Subject: Rezoning Petition Review

Date of Review: March 24, 2022 (*Revised April 18, 2022*)

Rezoning Petition #: 21-241

Location of Property: Approximately 1.85 acres located at the southeast intersection of Sardony Ln and E WT Harris Blvd, north of Rocky River Rd.

DRAWING NO: **SP-1**

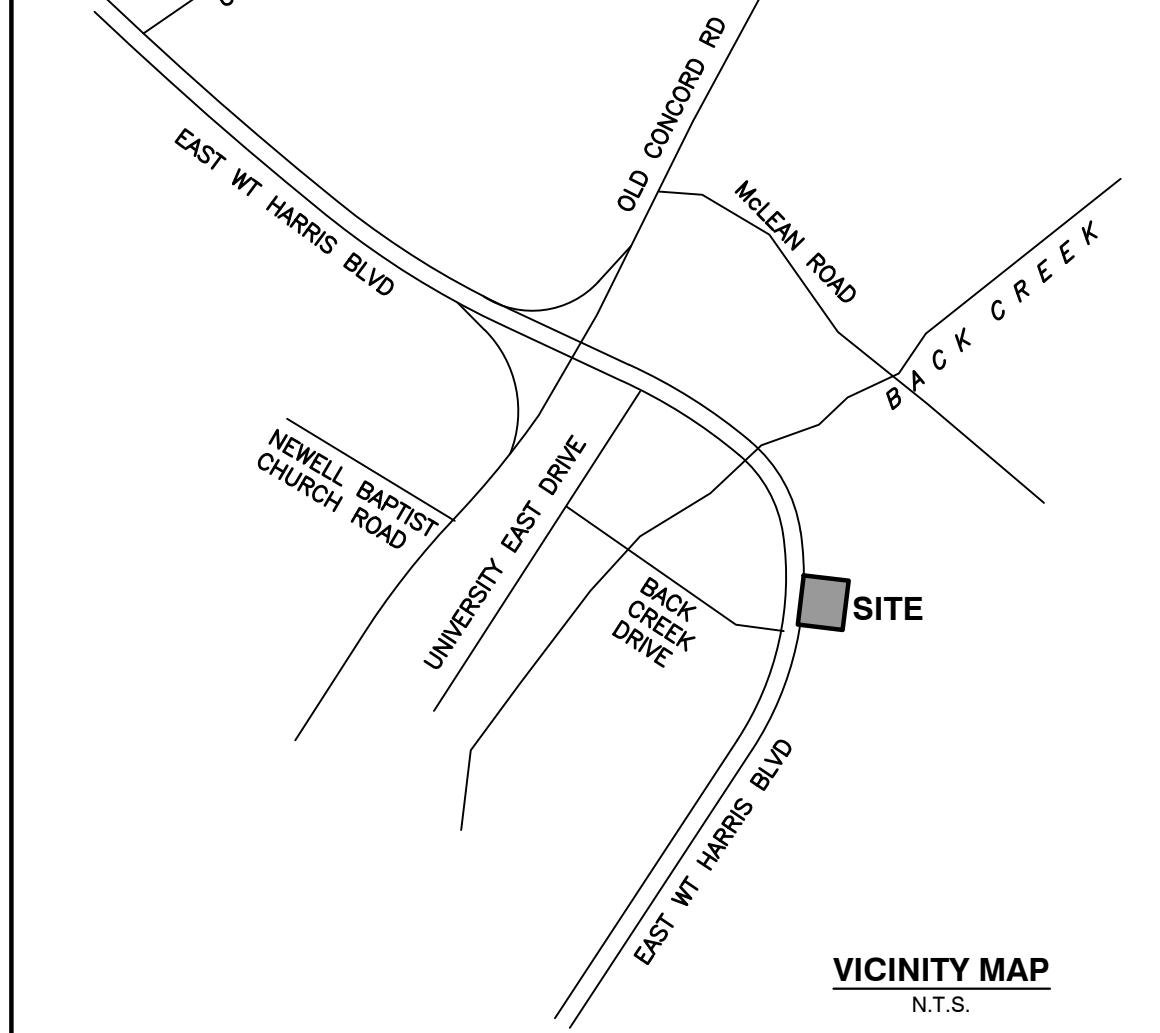
City of Charlotte GIS indicates a 50-ft Undisturbed PCSO Buffer across the site. Please show and label "Potential 50-ft Undisturbed PCSO Buffer" on the site plan. Any increase of impervious area within such buffers may not be allowed and is not approved with the rezoning process. Please include the following note under Environmental Features: *"Development within any SWIM/PCSO Buffer shall be coordinated with and subject to approval by Charlotte-Mecklenburg Storm Water Services and mitigated if required by City ordinance. Petitioner acknowledges intermittent/perennial stream delineation reports are subject to review and approval upon submission of development plans for permitting and are not approved with rezoning decisions."*

Due to revisions (4/18/22): No additional recommendations are needed at this time.
